# CITY OF ALBUQUERQUE

Site: Wecks Restaurant, 7301 Paseo Del Norte NE

**Re: Drainage Ordinance (14-5-2-1) Violations for Erosion and Sediment Control**

EROSION AND SEDIMENT CONTROL PLAN

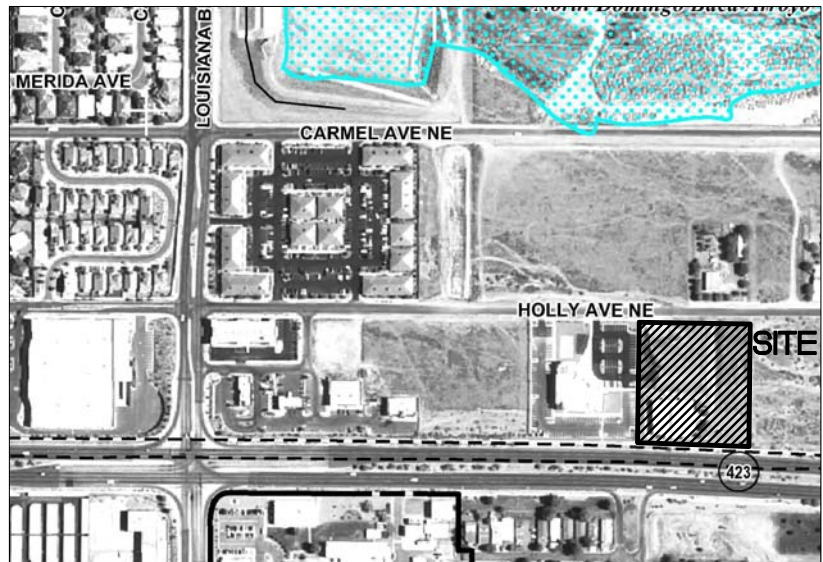
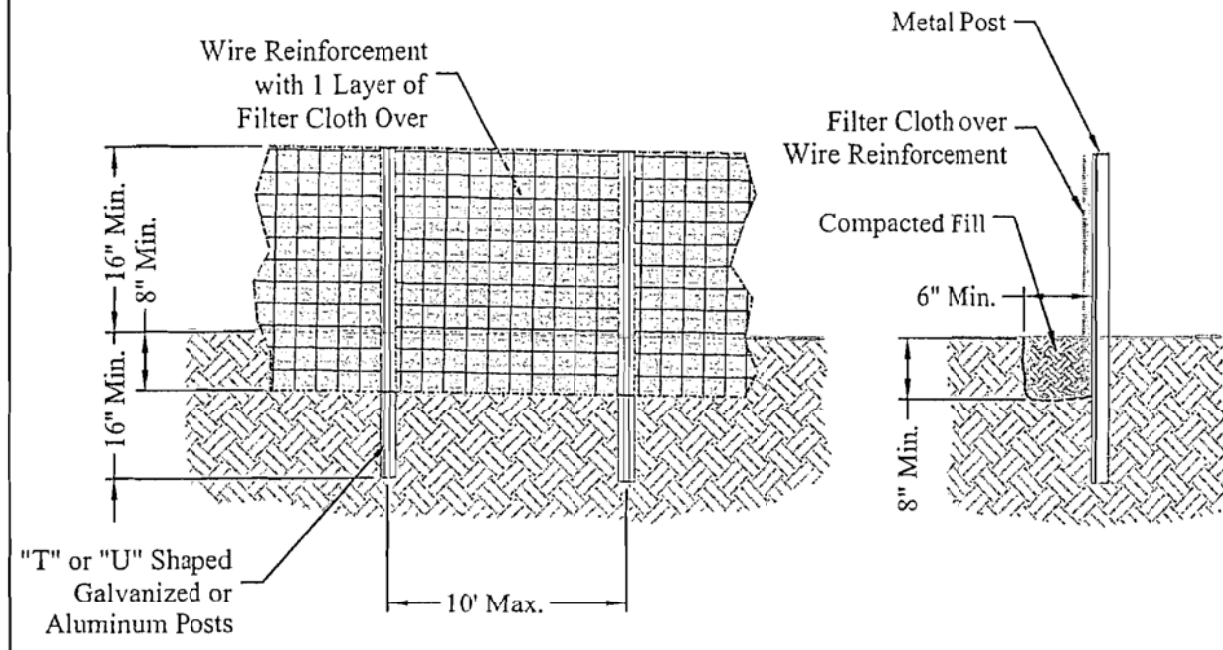
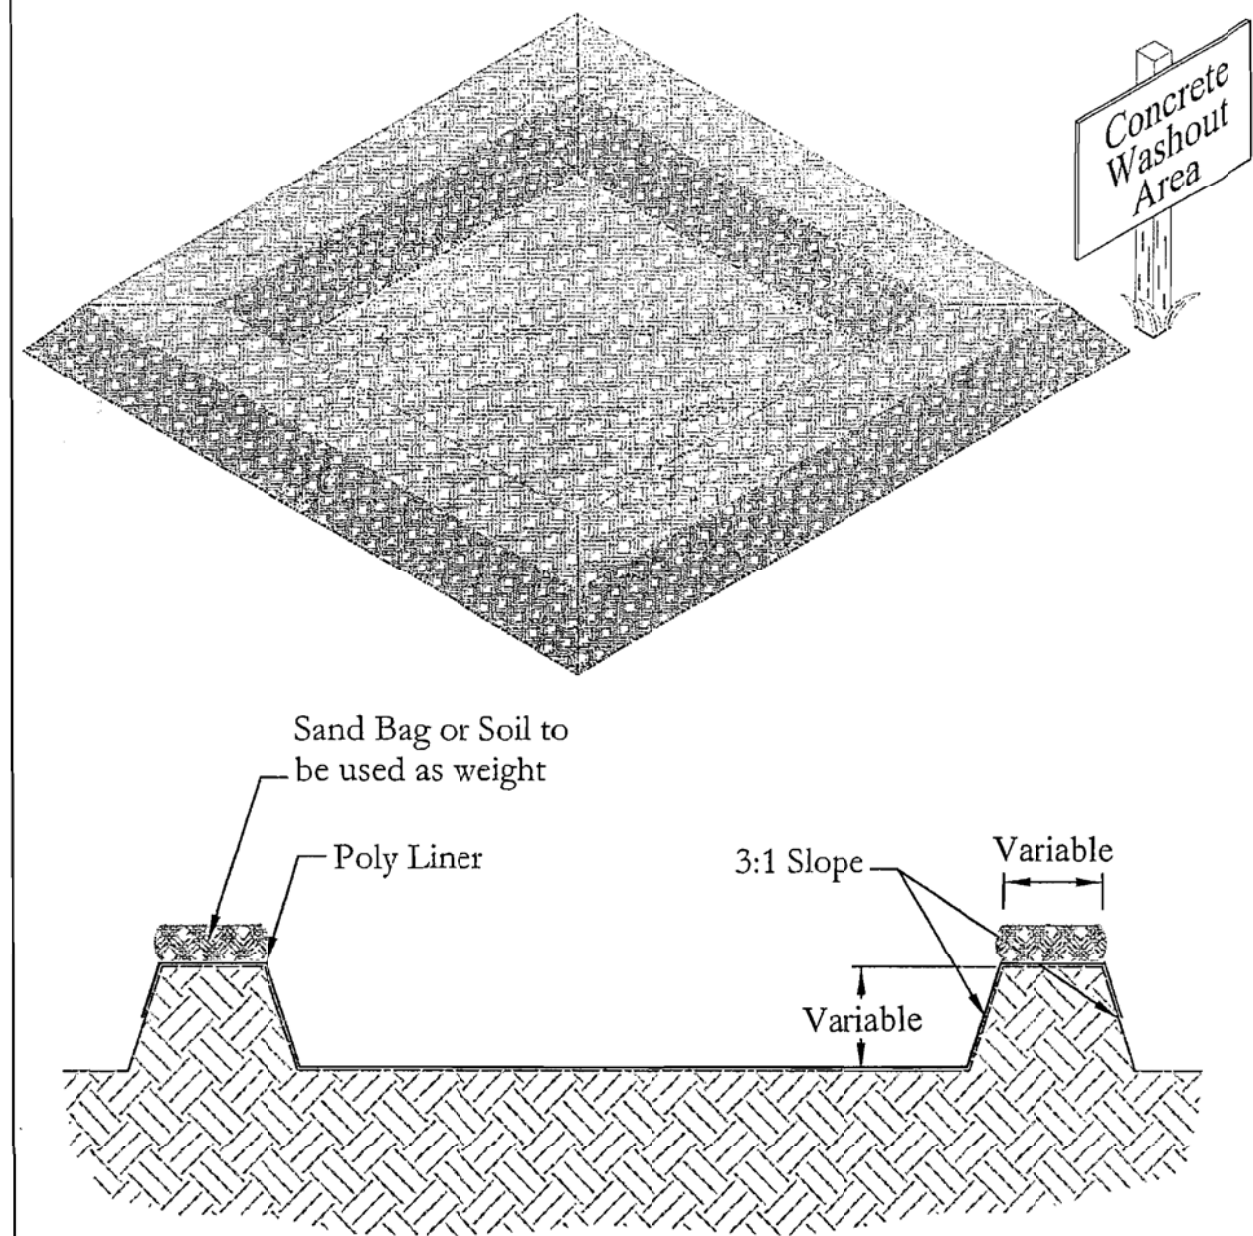
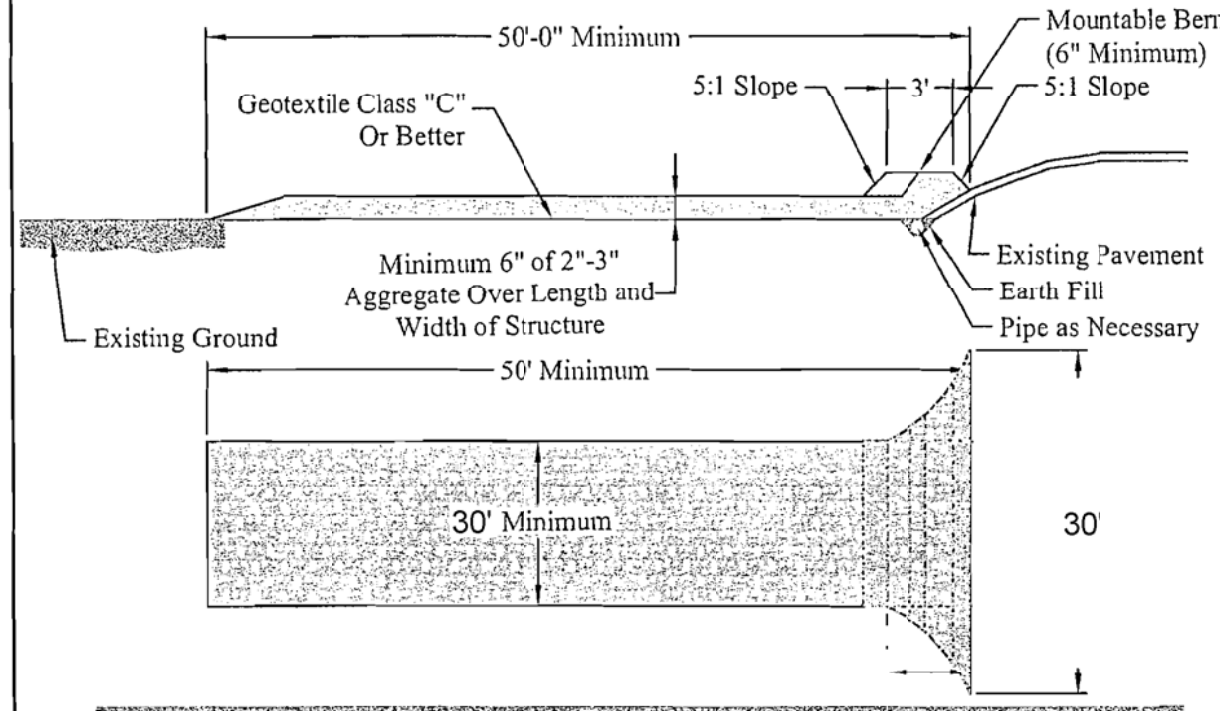
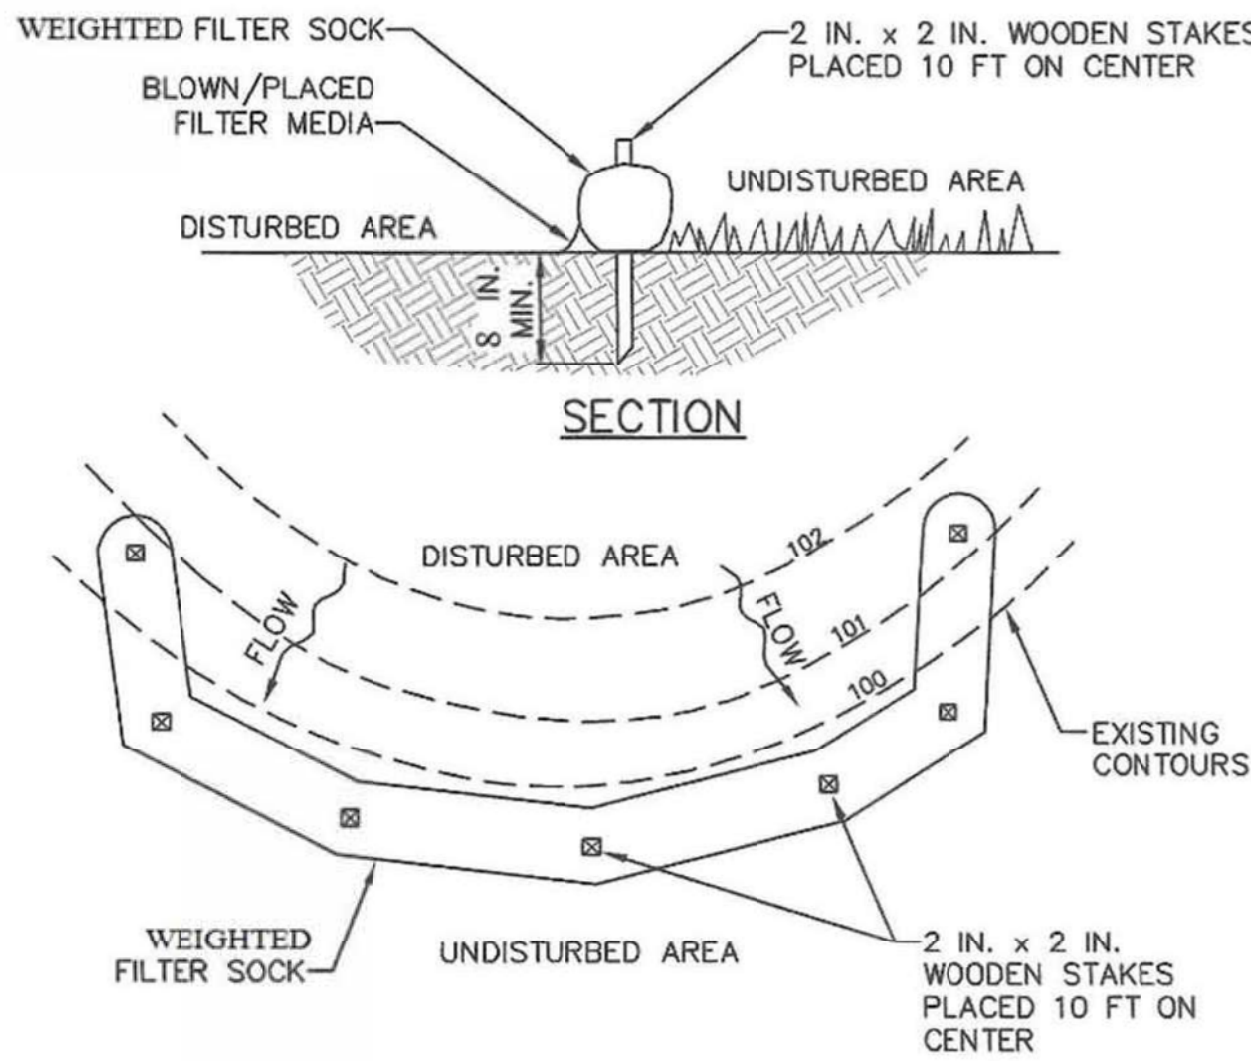
1. This project will disturb one acre or greater. Earth disturbance has begun at the site and stormwater controls have not been implemented.

No Stormwater Controls along Holly Ave.

West edge of site at north end. No stormwater controls.

South edge of site. No stormwater controls.

1. Implement stormwater controls per approved Erosion and Sediment Control Plan.
